## EL PASO COUNTY GRADING AND EROSION CONTROL PLAN CHECKLIST

EPC Project Number: PUDSP236

SHEET DT 10

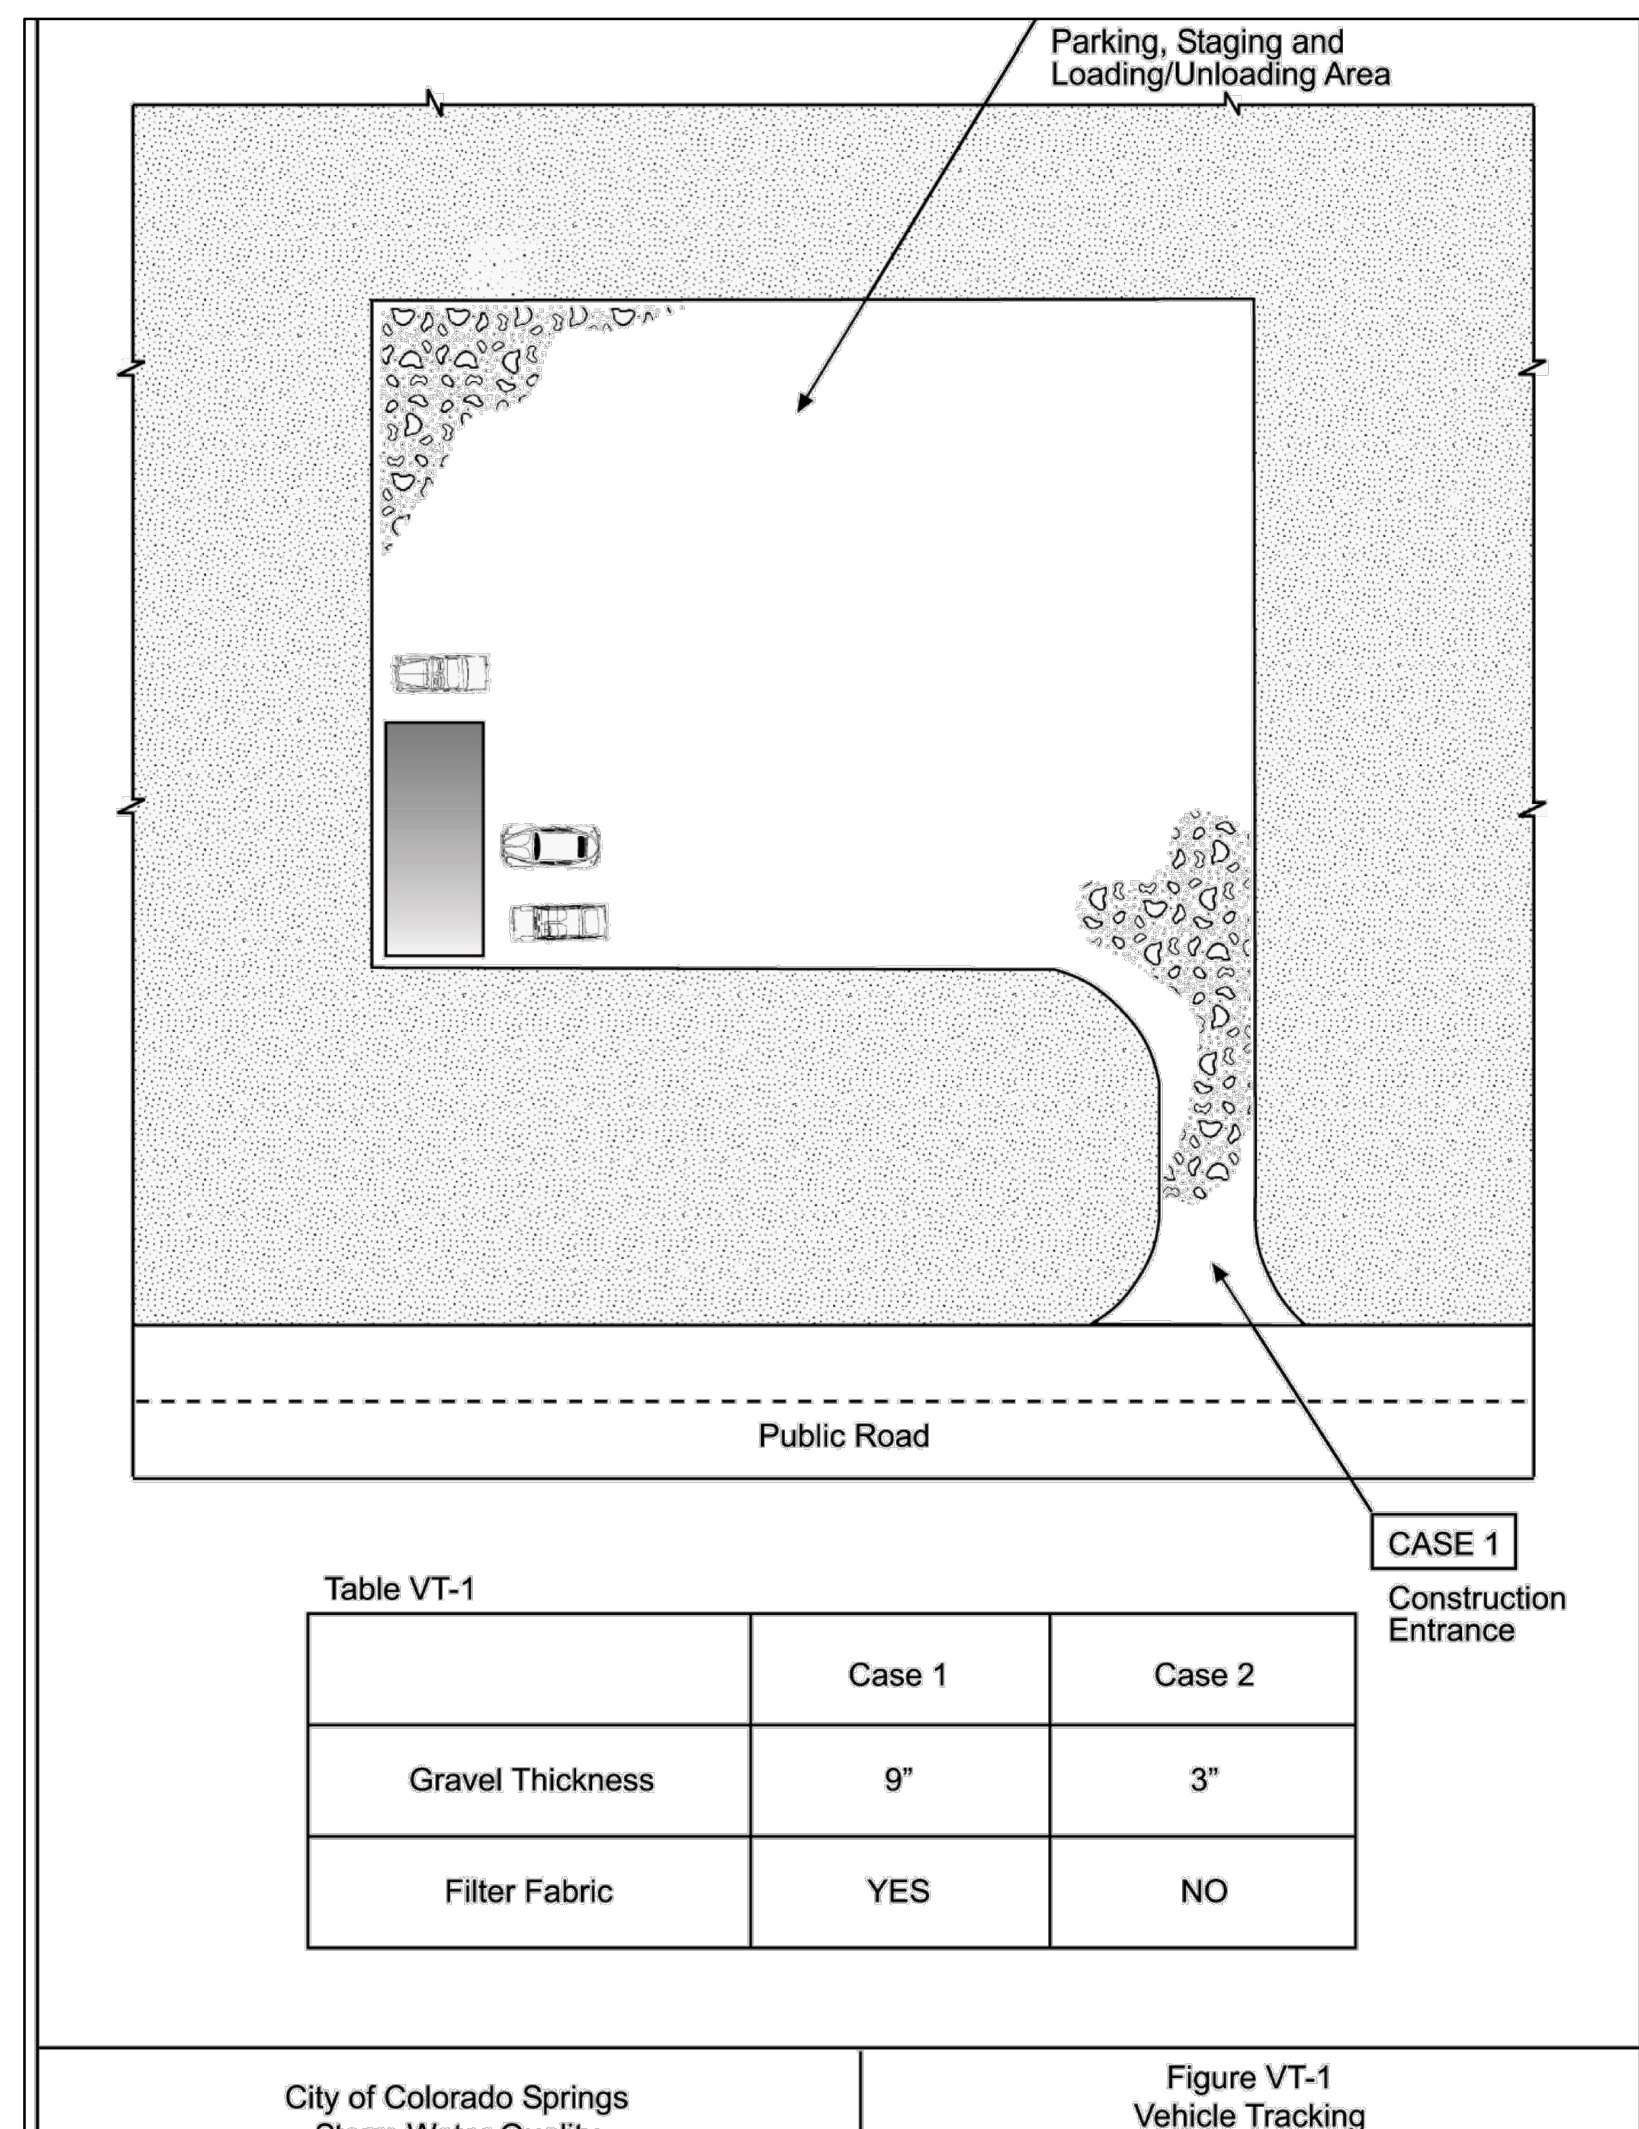
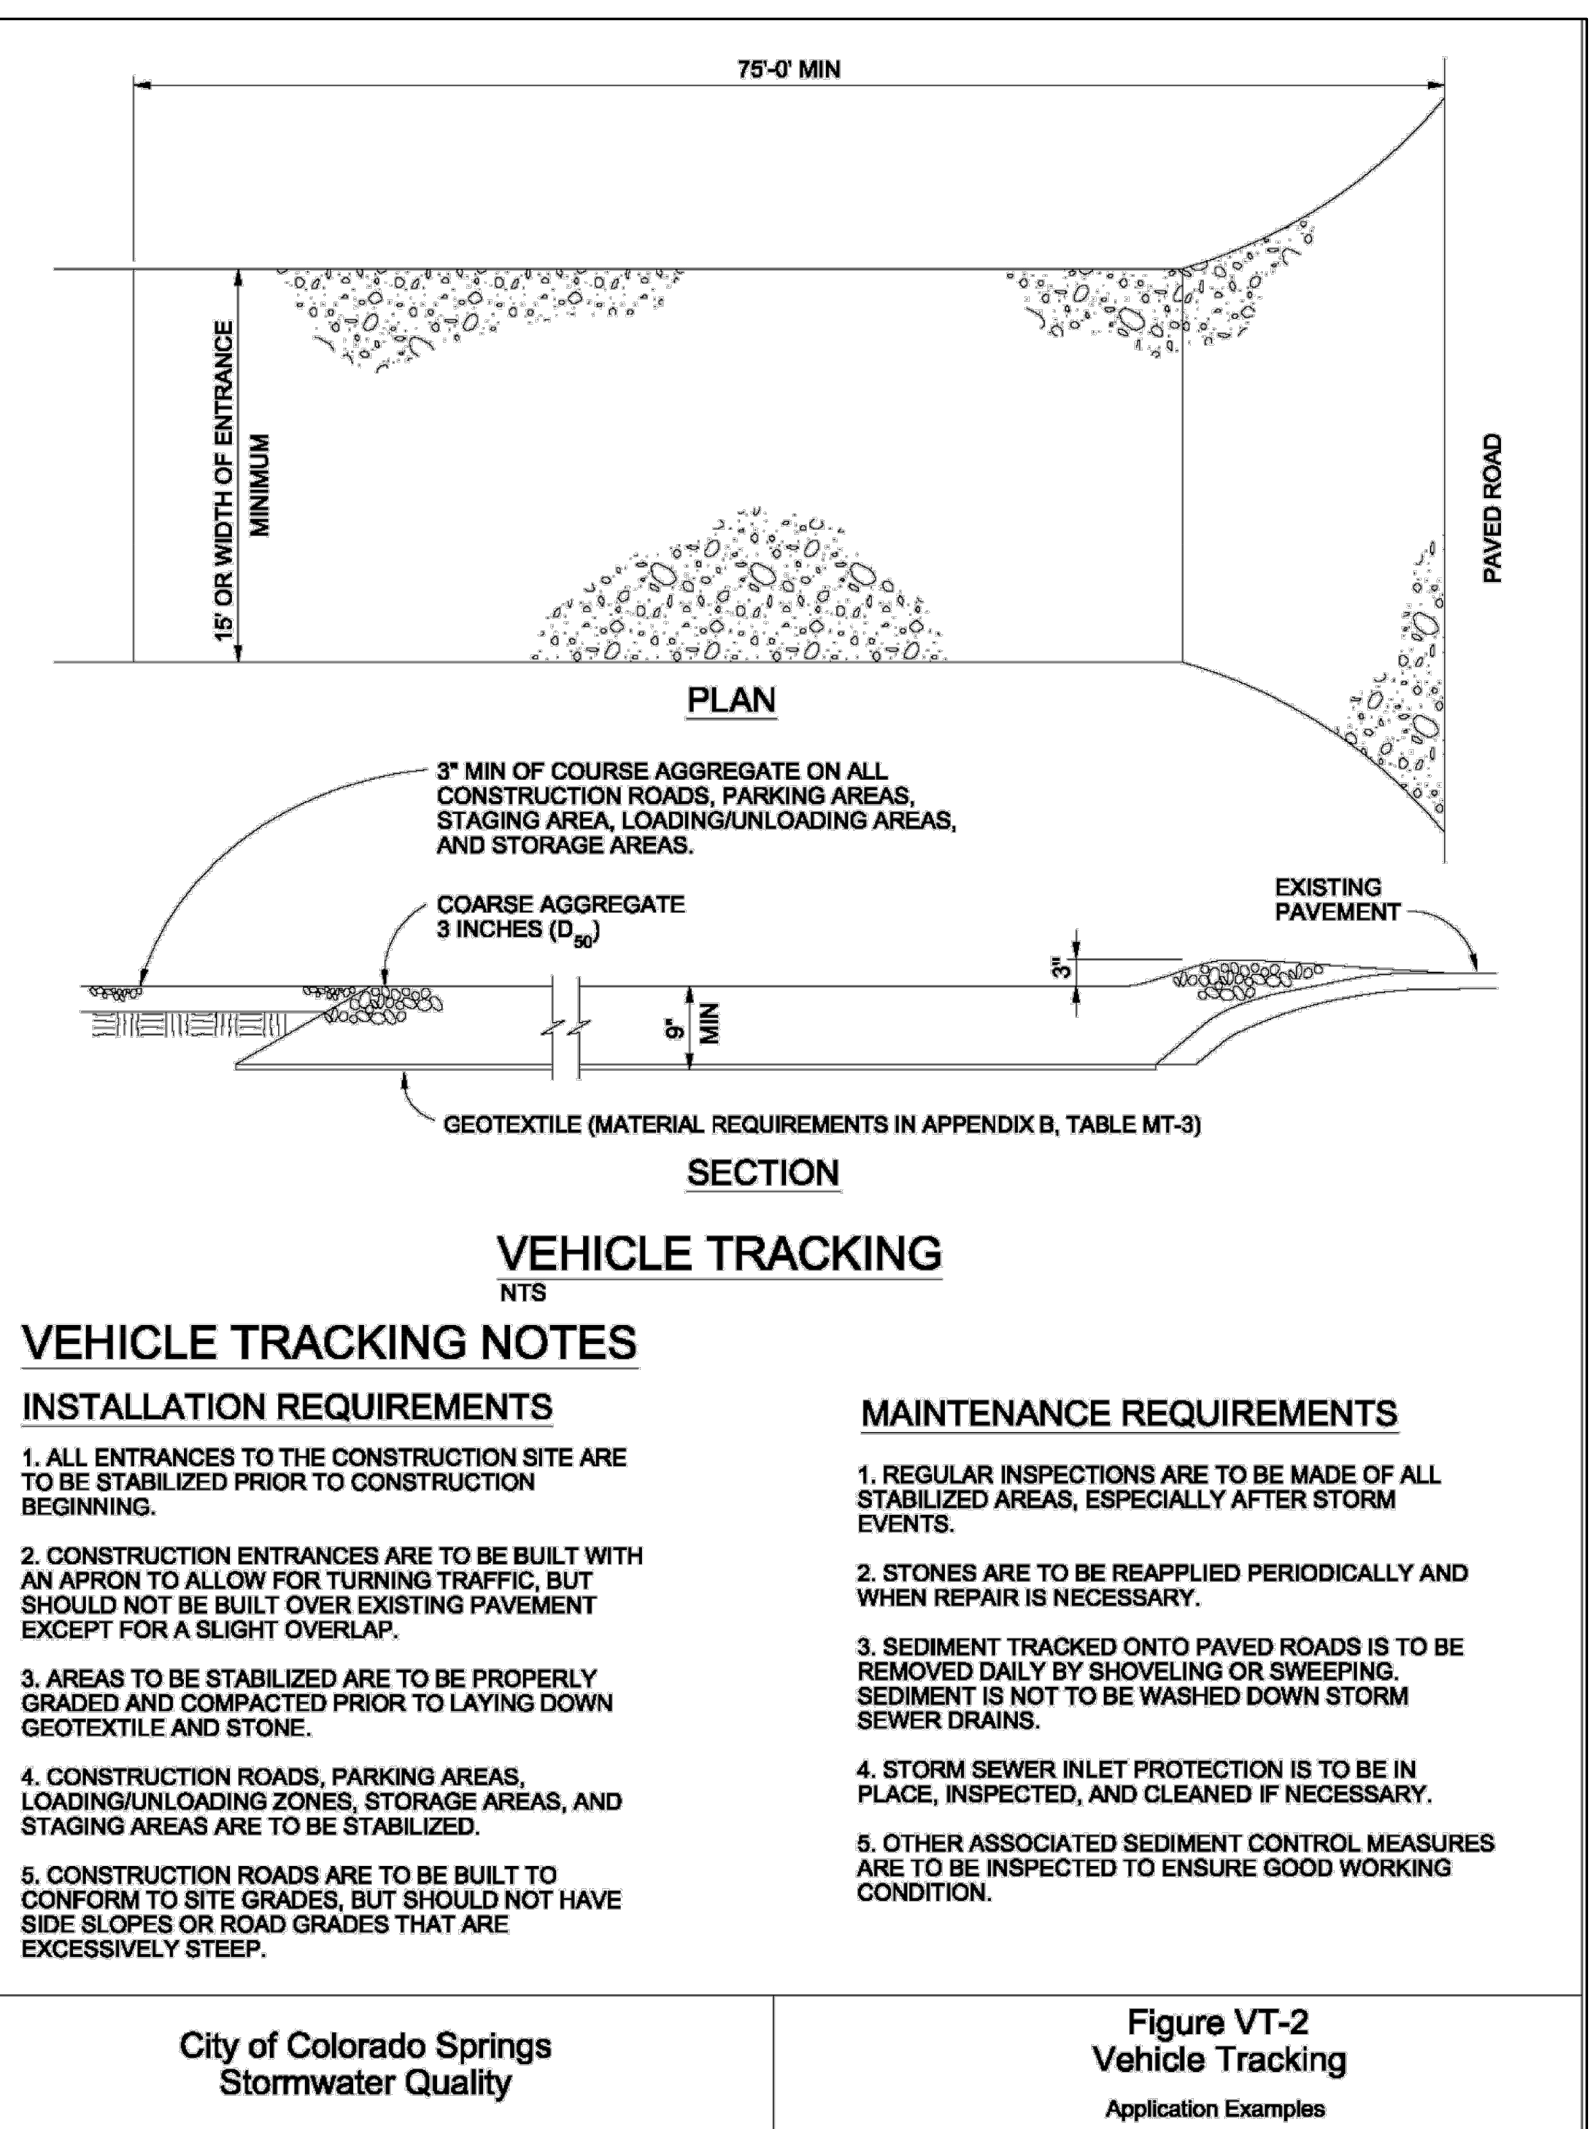
v	All proposed temporary construction control measures, structural and non-structural. Temporary construction control measures shall be identified by phase of implementation to include "initial," "interim," and "final" or shown on separate phased maps identifying each phase		Y
w	Vehicle tracking provided at all construction entrances/exits. Construction fencing, barricades, and/or signage provided at access points not to be used for construction <span style="border: 1px solid black; padding: 2px;">See my comment on Sht 3</span>		N
x	Temporary sediment ponds provided for disturbed drainage areas greater than 1 acre		Y

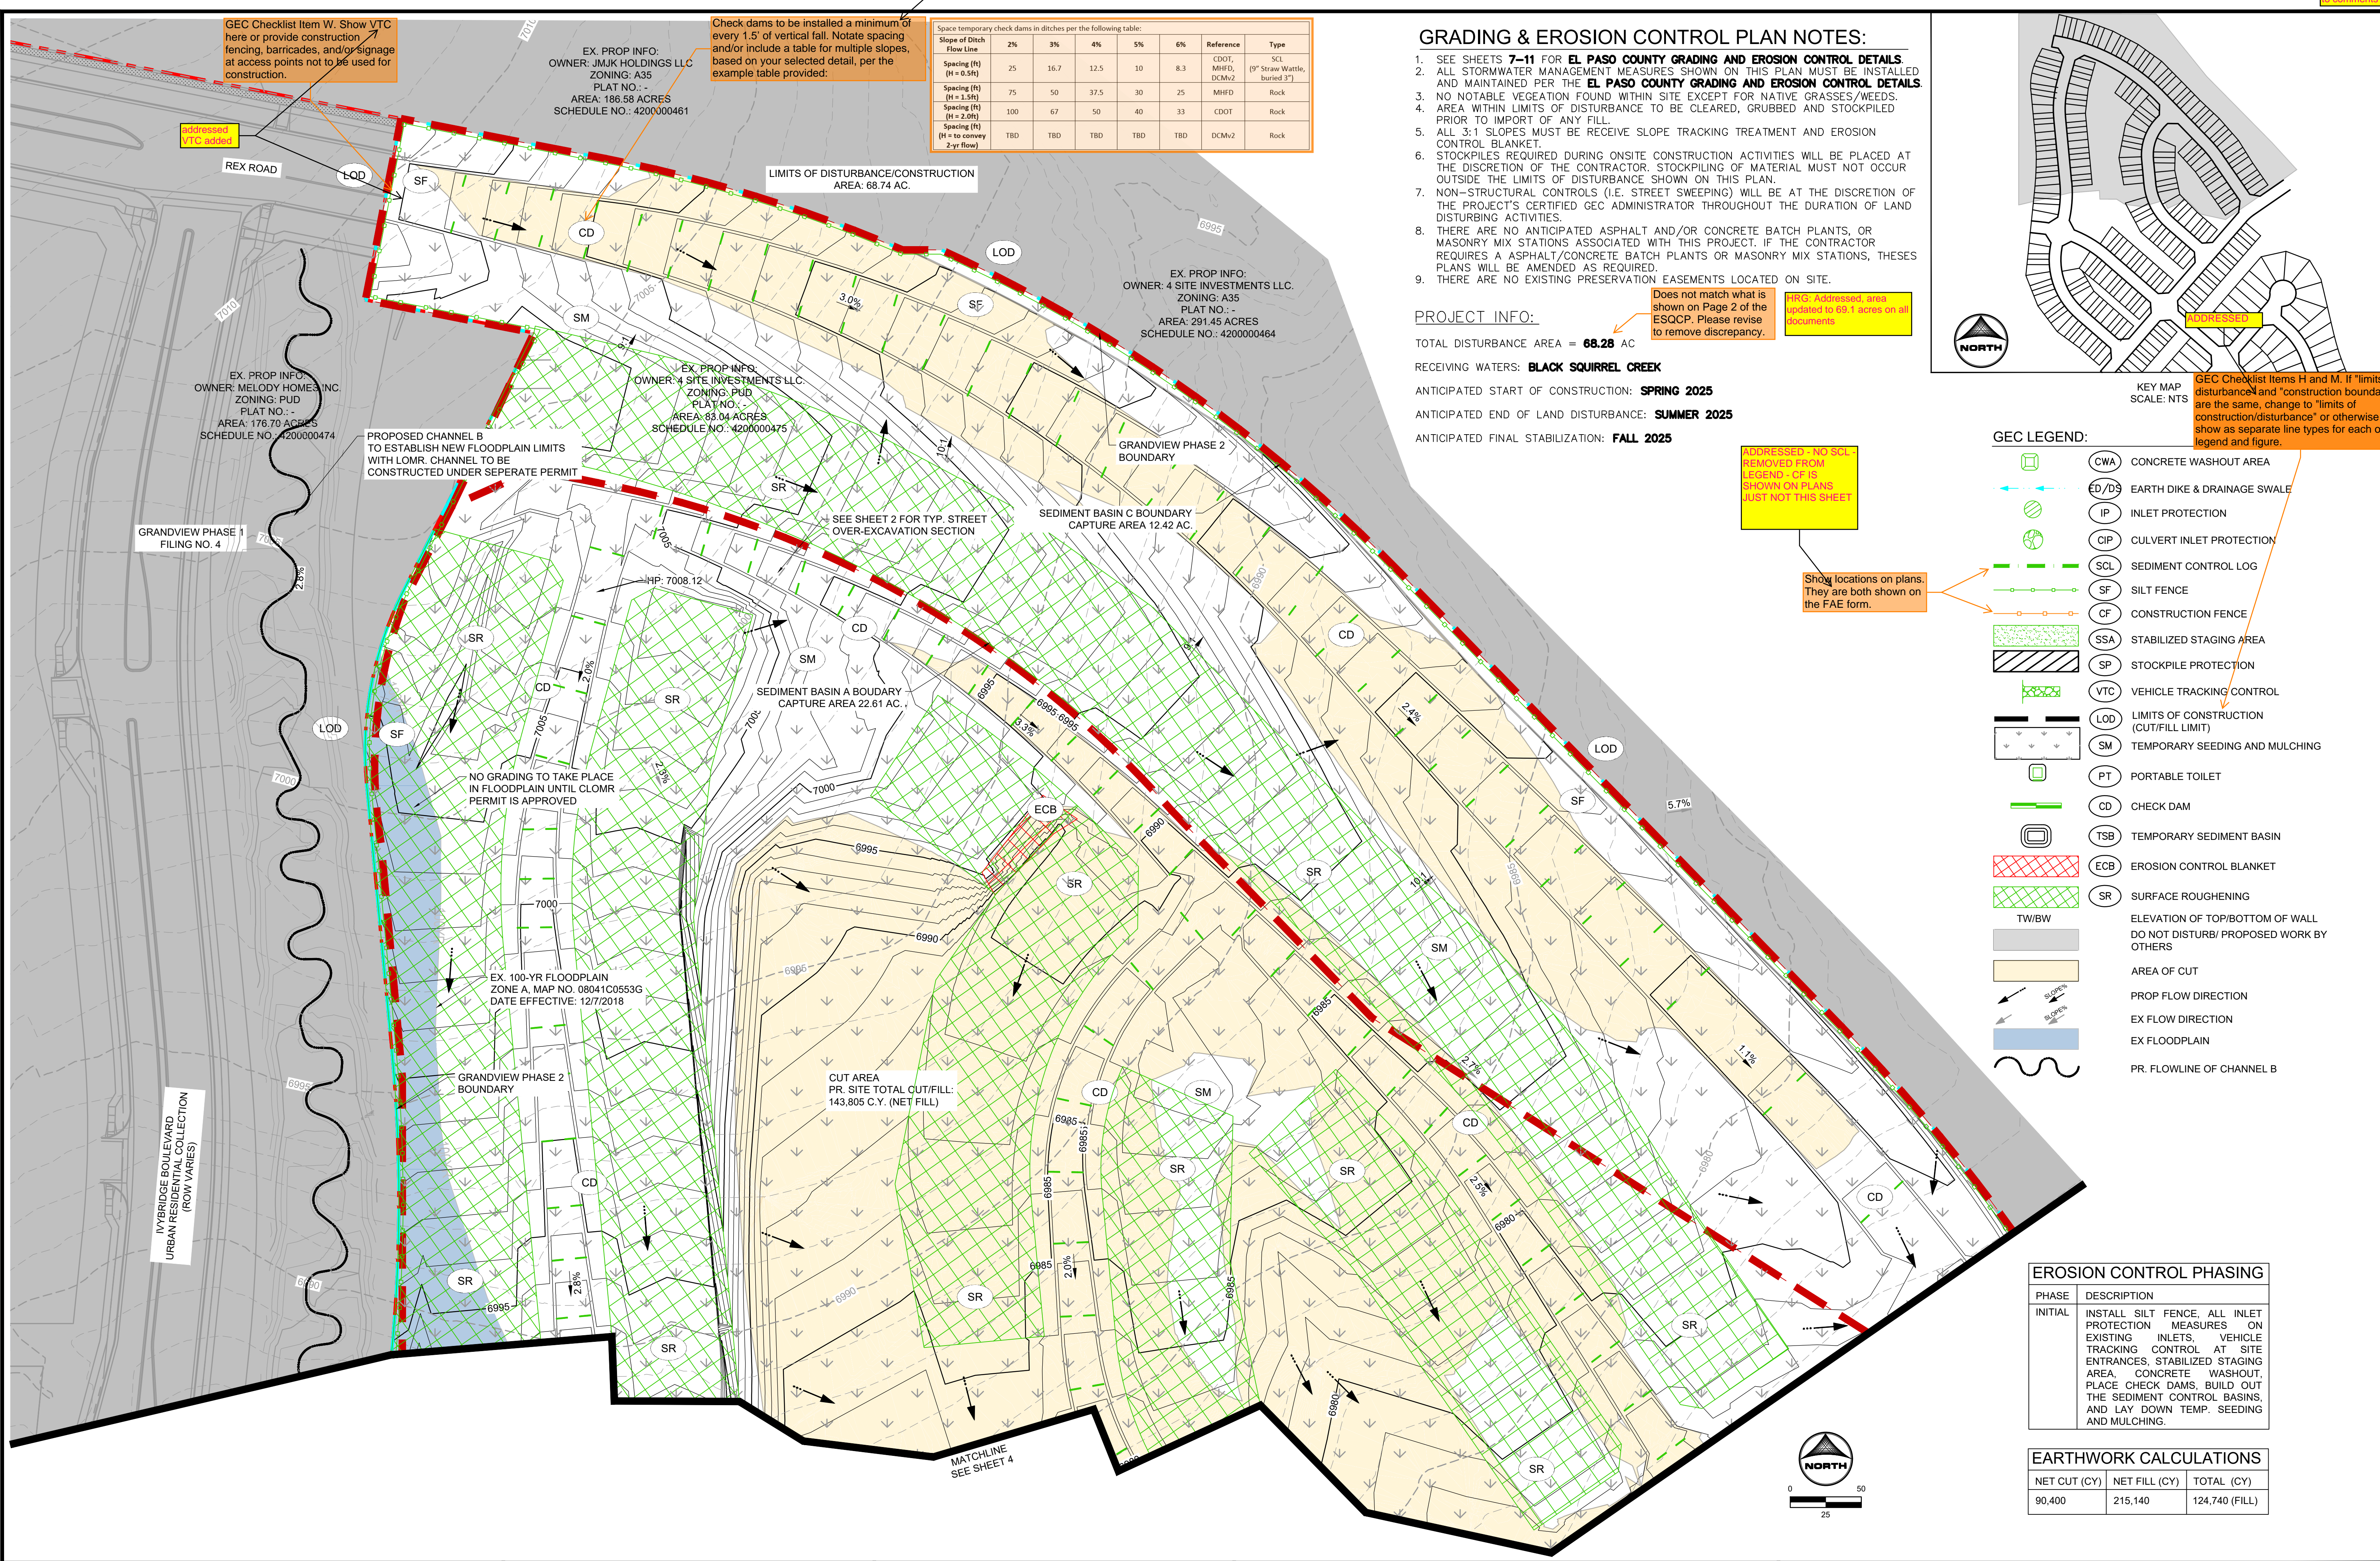
l	Existing and proposed contours 2 feet or less (except for hillside)		Y
m	Limits of disturbance delineating all anticipated areas of soil disturbance		N
n	Identify and protect areas outside of the construction site boundary with existing fencing, construction fencing or other methods as appropriate		Y
o	Off-site grading clearly shown and called out		Y
p	Areas of cut and fill identified		Y
q	Conclusions from soils/geotechnical report and geologic hazards report incorporated in grading design (slopes, embankments, materials, mitigation, etc.) <span style="border: 1px solid black; padding: 2px;">Address Charlene's comments in the Soils Report</span>		N
r	Proposed slopes steeper than 3:1 with top and toe of slope delineated. Erosion control blanketing or other protective covering required		Y
s	Stormwater flow direction arrows		Y
t	Location of any dedicated asphalt / concrete batch plants		N/A
u	Areas used for staging, storage of building materials, soils (stockpiles) or wastes. The use of construction office trailers requires PCD permitting		Y
